Summary of Submissions and Proponents Response (20/01/11)

DRAWING Shadow Diagrams

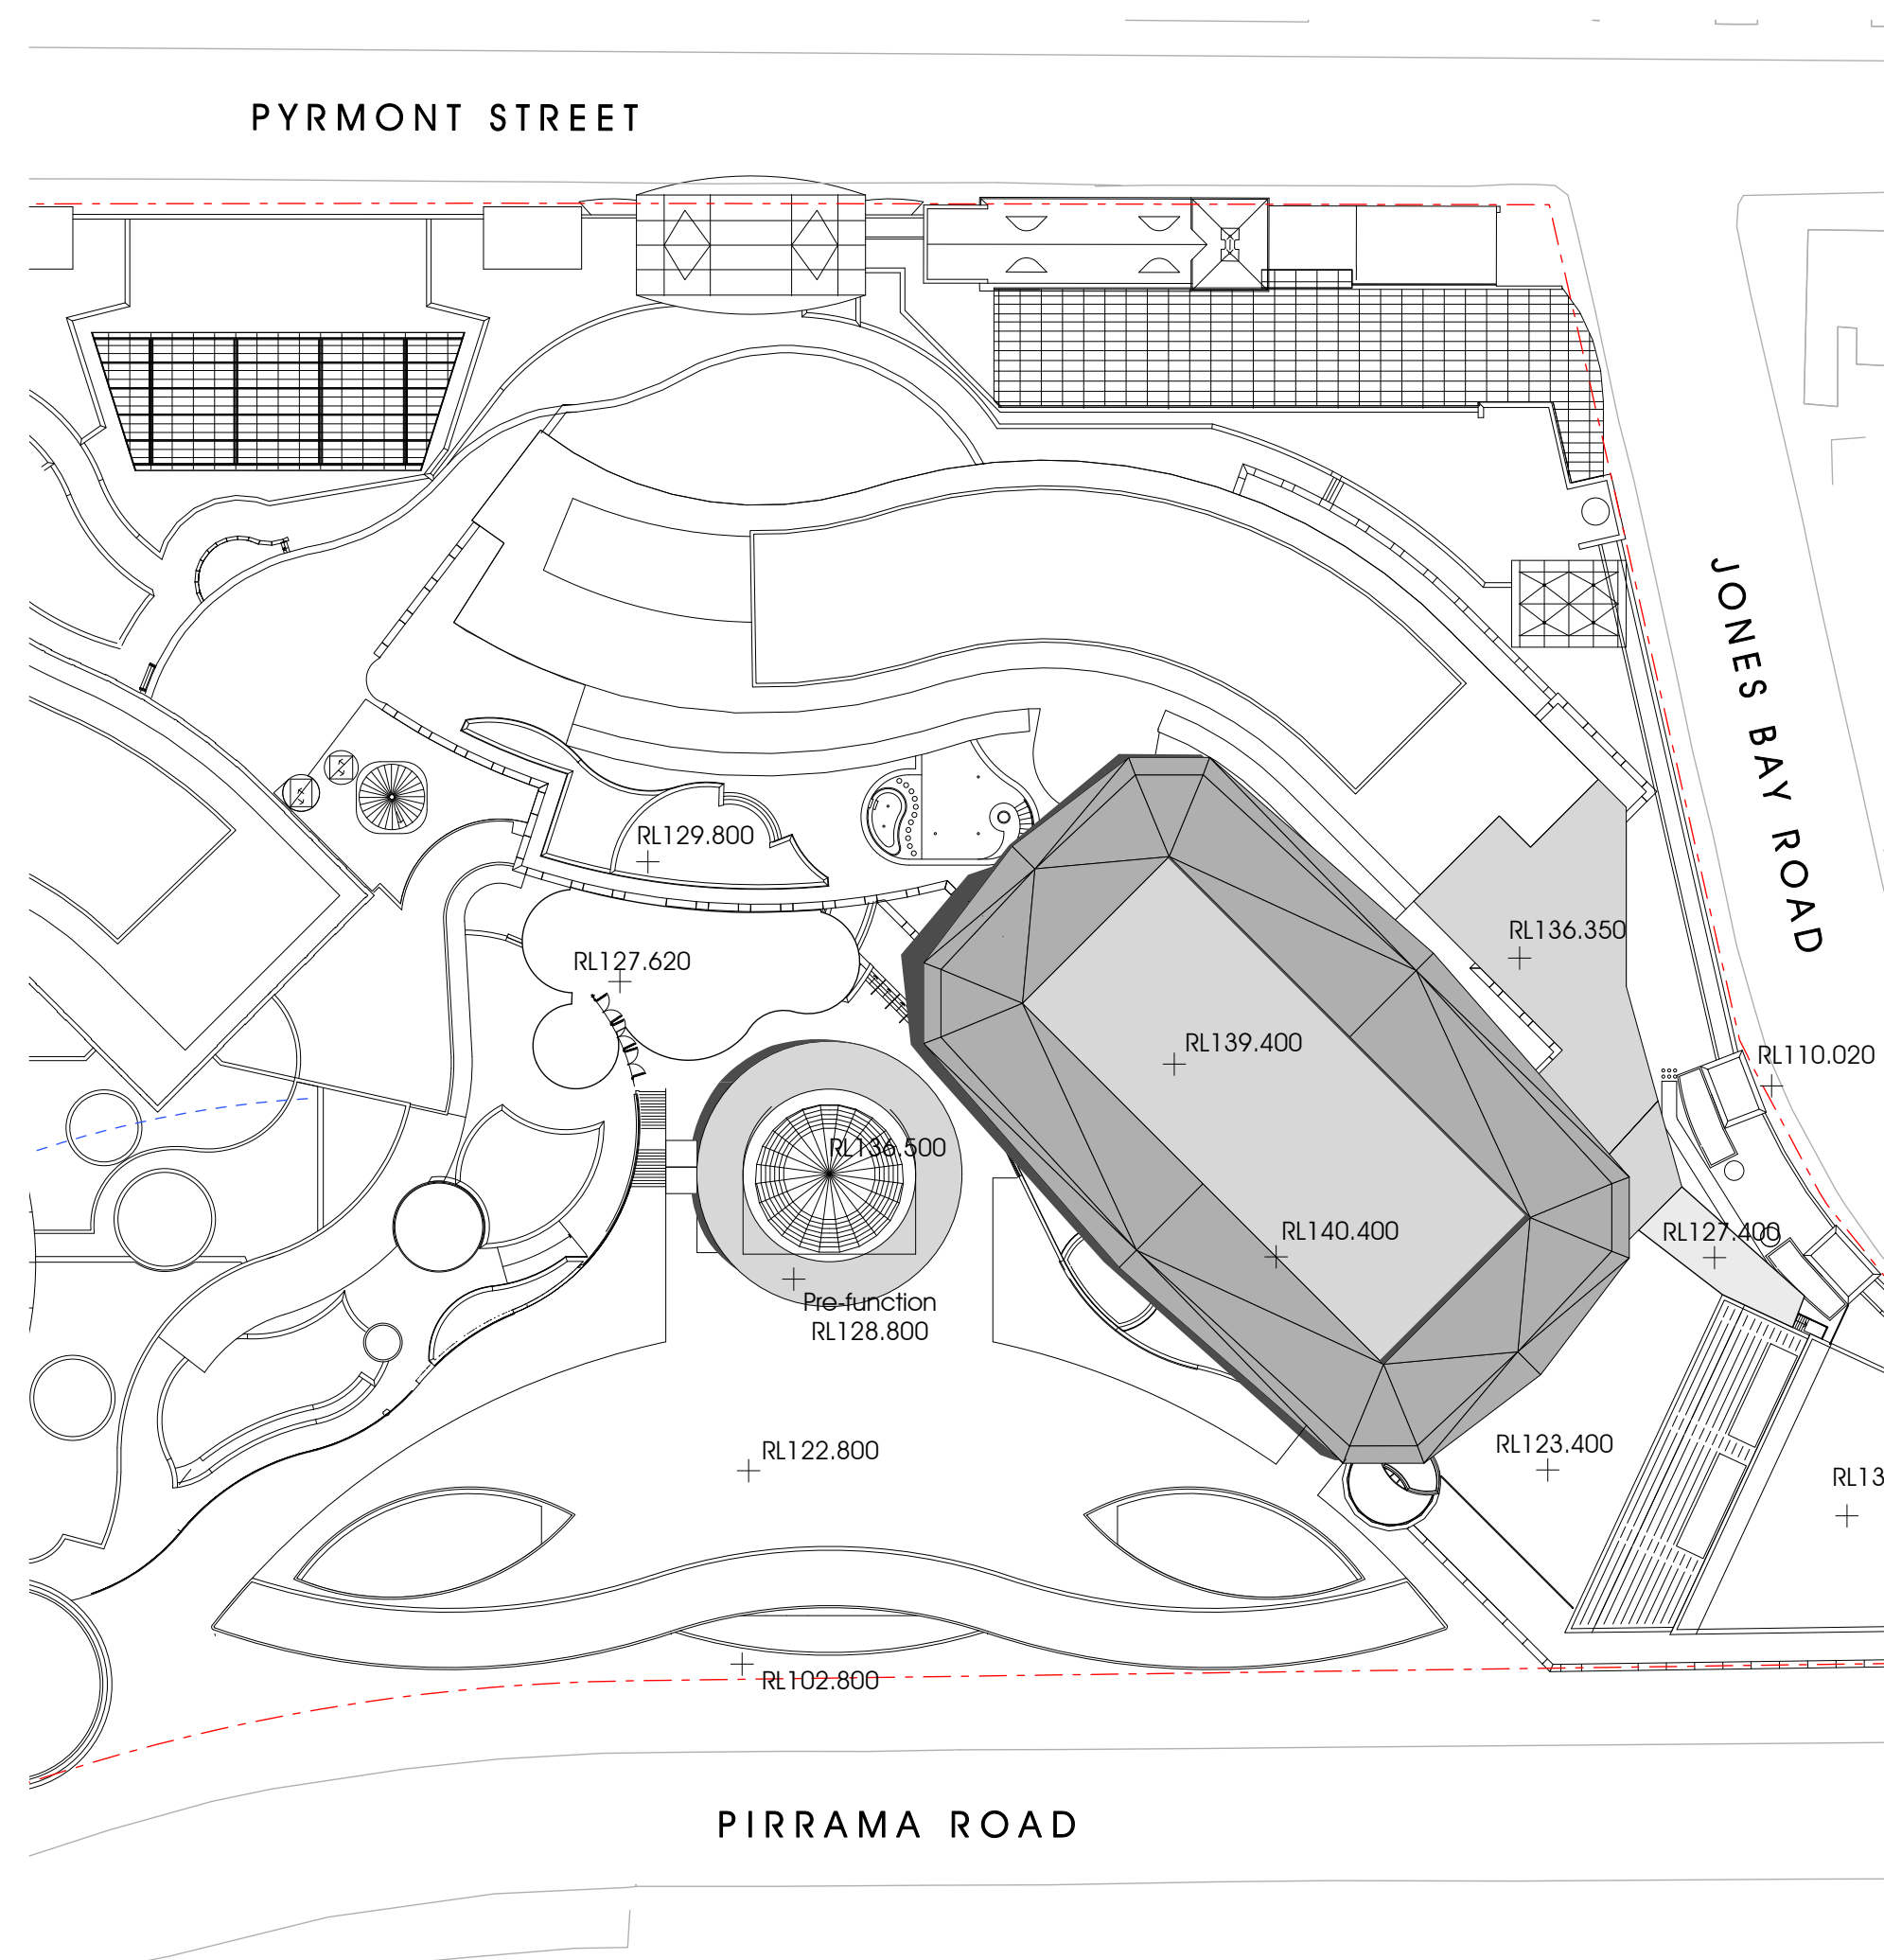
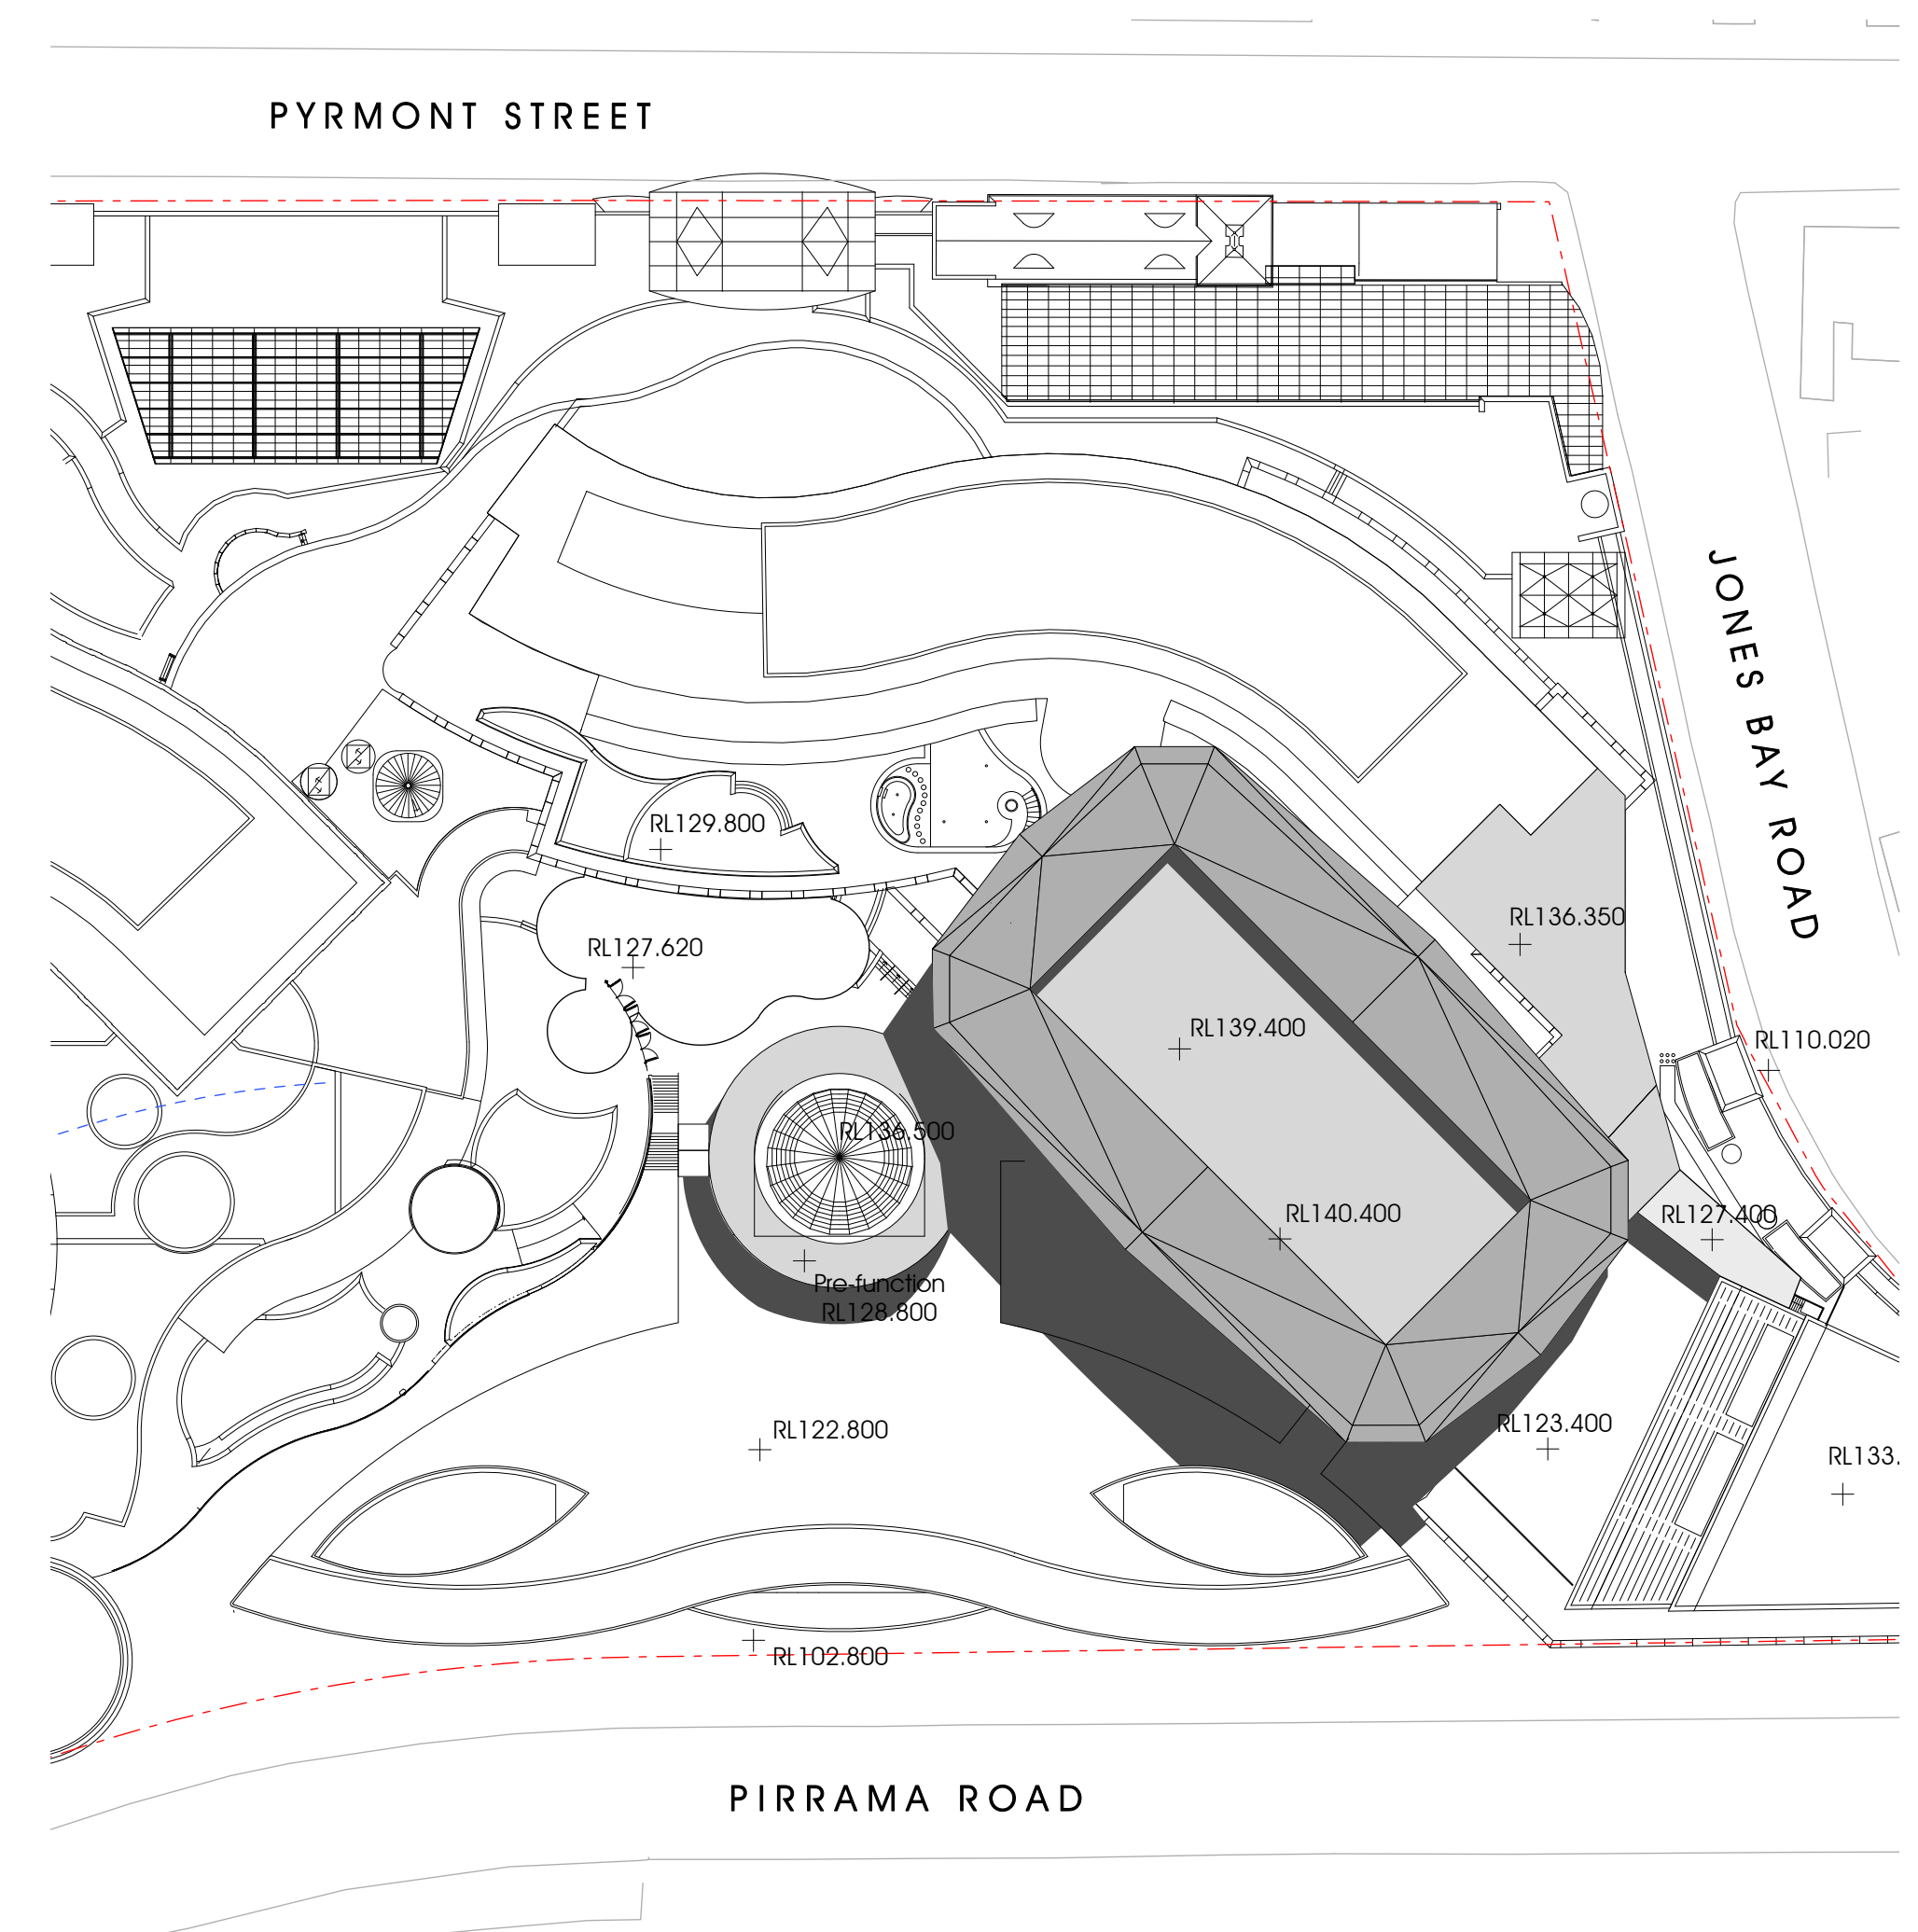
<p>Robert Wirth, Warwick Saunders, Zena Vaasssen, Stafford Van Putten 14 & 16 Pymont St, Pymont 11/12/10</p>	<p>Proposed development will adversely affect the quality of life for residents of 14, 16 and 18 Pymont Street (as well as the Watermark Building). The increased height will result in loss of already limited sunlight access to the rear of these properties. The issue of loss of light and its impact on the community has not been addressed by the Casino developers.</p>	<p>These properties are located towards the north-west of the MUEF. Submitted shadow diagrams illustrate that the MUEF will not cause overshadowing to these terraces.</p>
